23 Ocean Avenue – 4 residential units, app. 2,400 SF office (updated 9/22/16)

LEVEL III SITE PLAN REVIEW (14-526)

SUBDIVISION REVIEW (14-497)

1 : East Elevation : 1/4 in = 1 ft

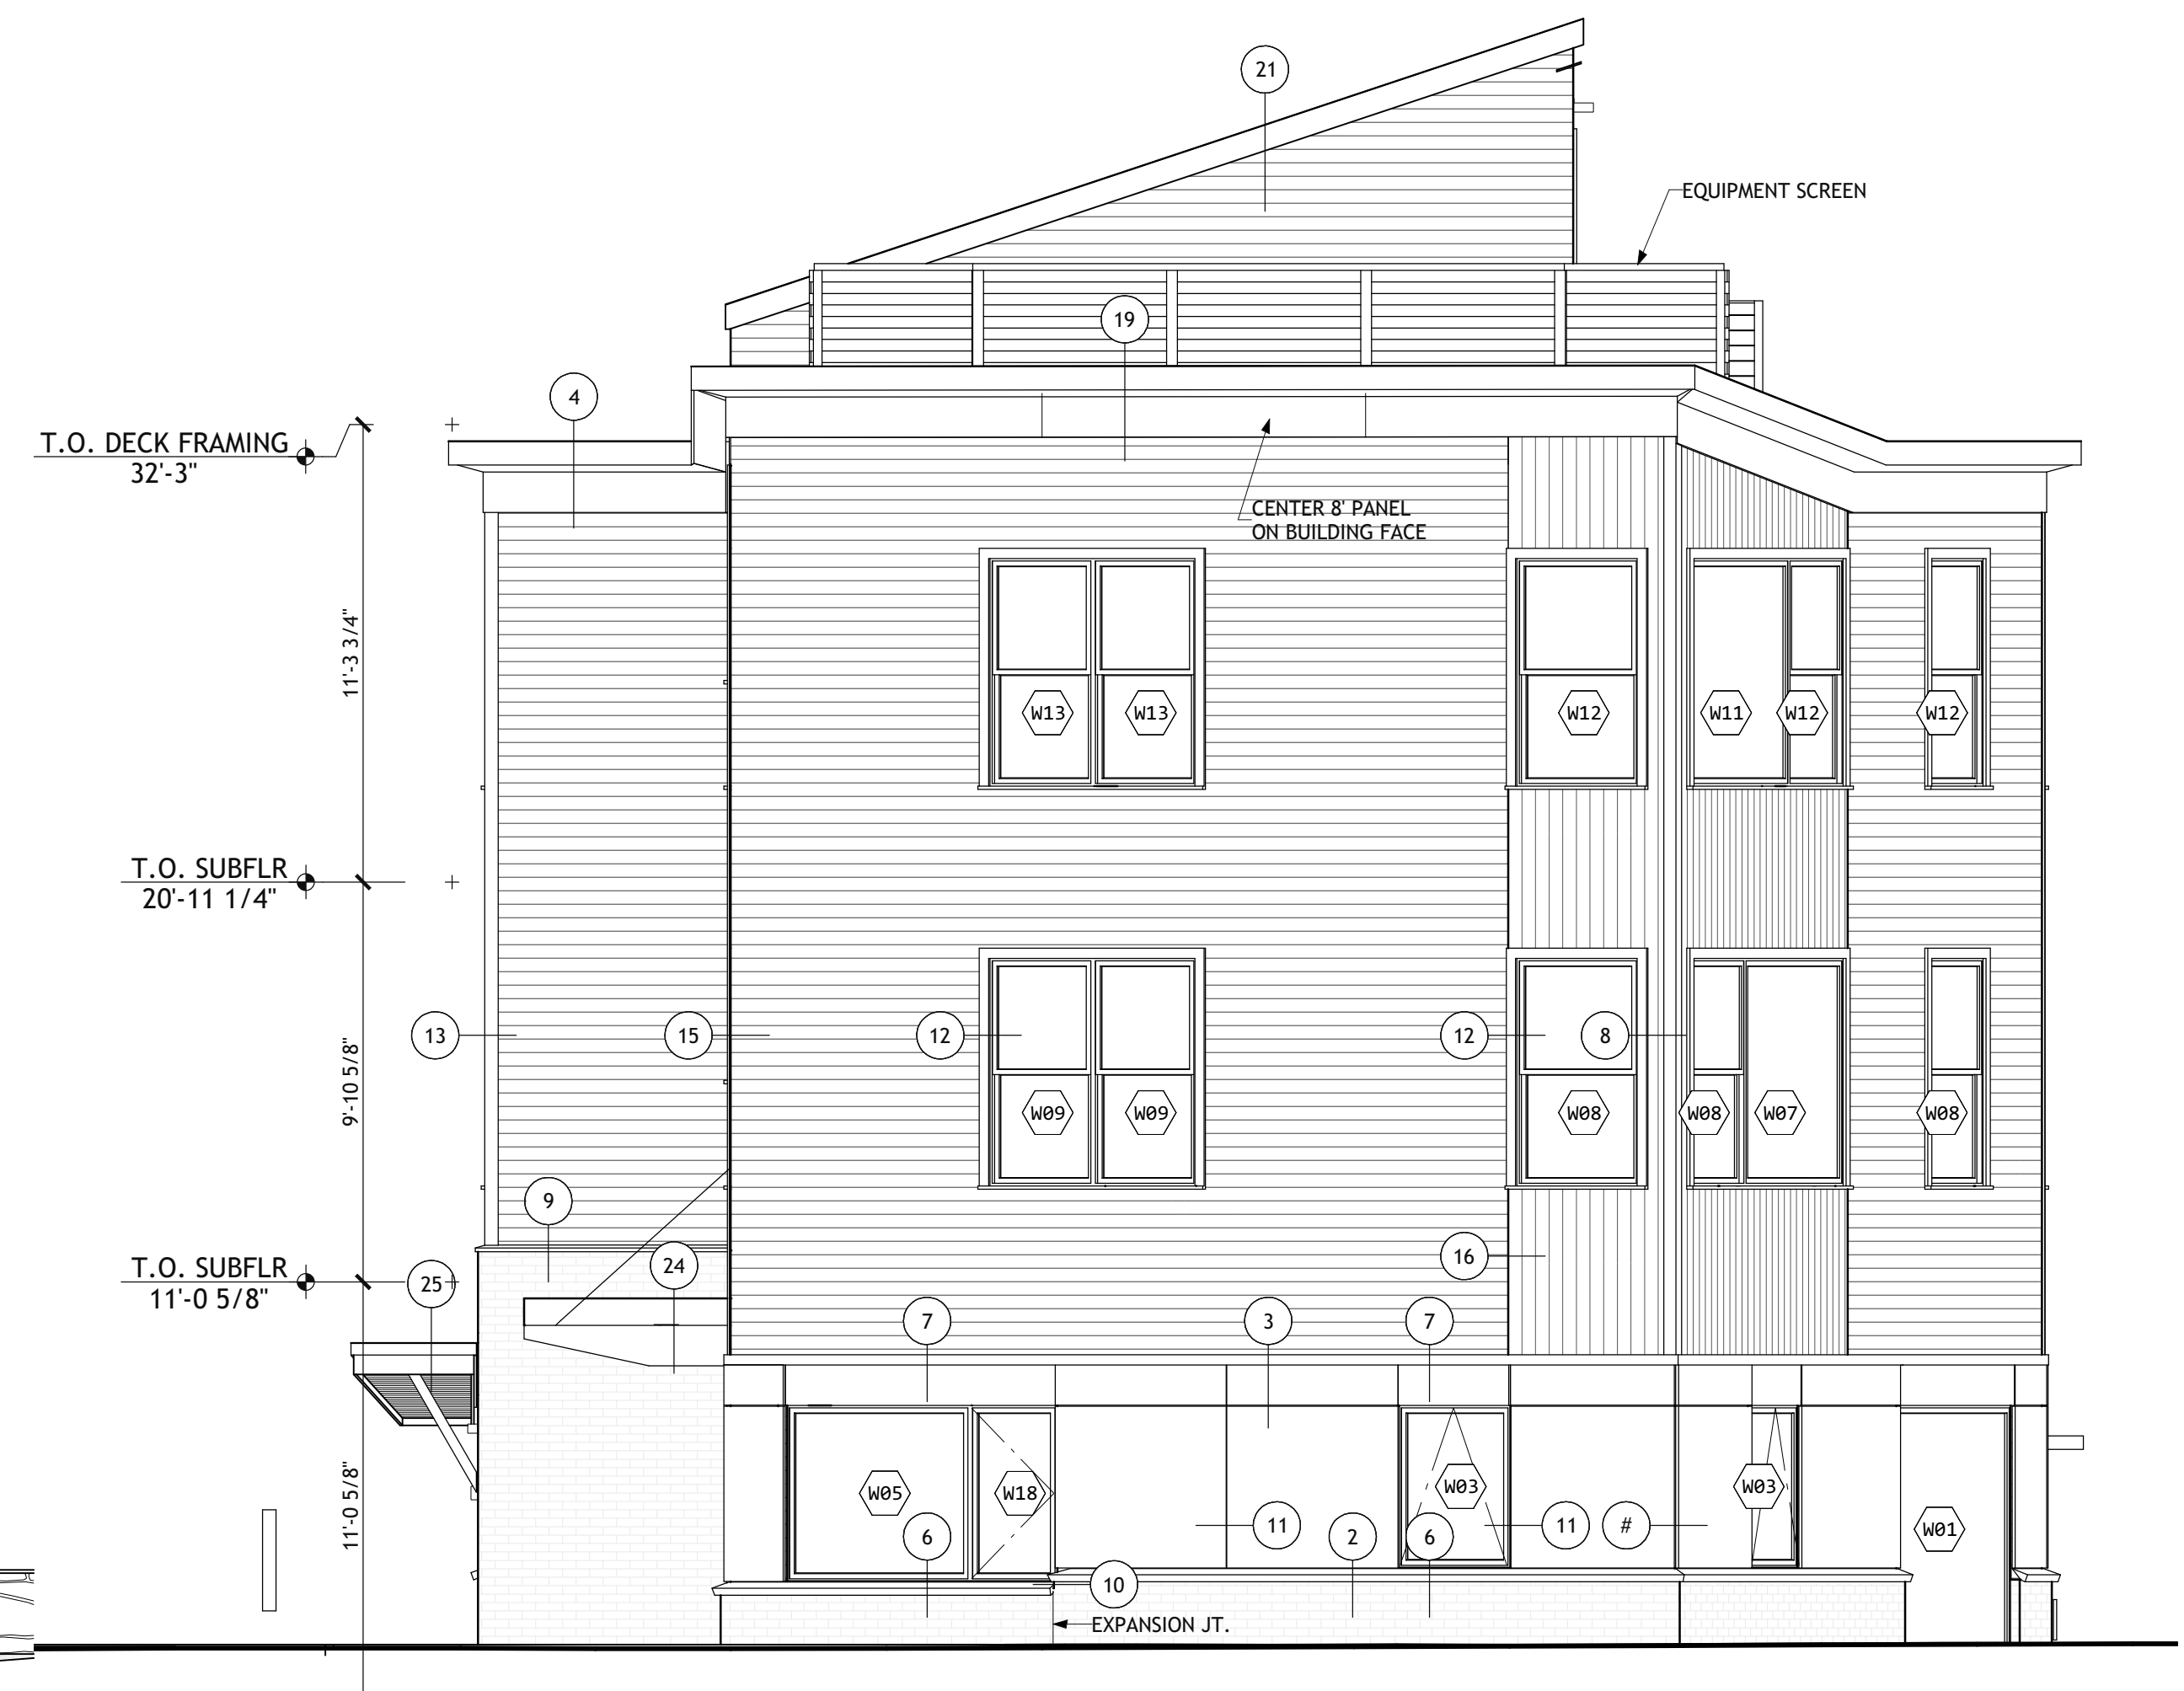
c. Availability and Adequate Capacity of Public Utilities	<ul style="list-style-type: none"> • Overhead electric is not permitted. Please confirm a plan for underground electrical with CMP Modified electrical to provide underground from across Hersey. Will confirm notes are okay with DPW. • Will be condition of approval around potential for removing pole.
Site Design	a. Massing, Ventilation and Wind Impact	• Where is HVAC venting? Roof mounted
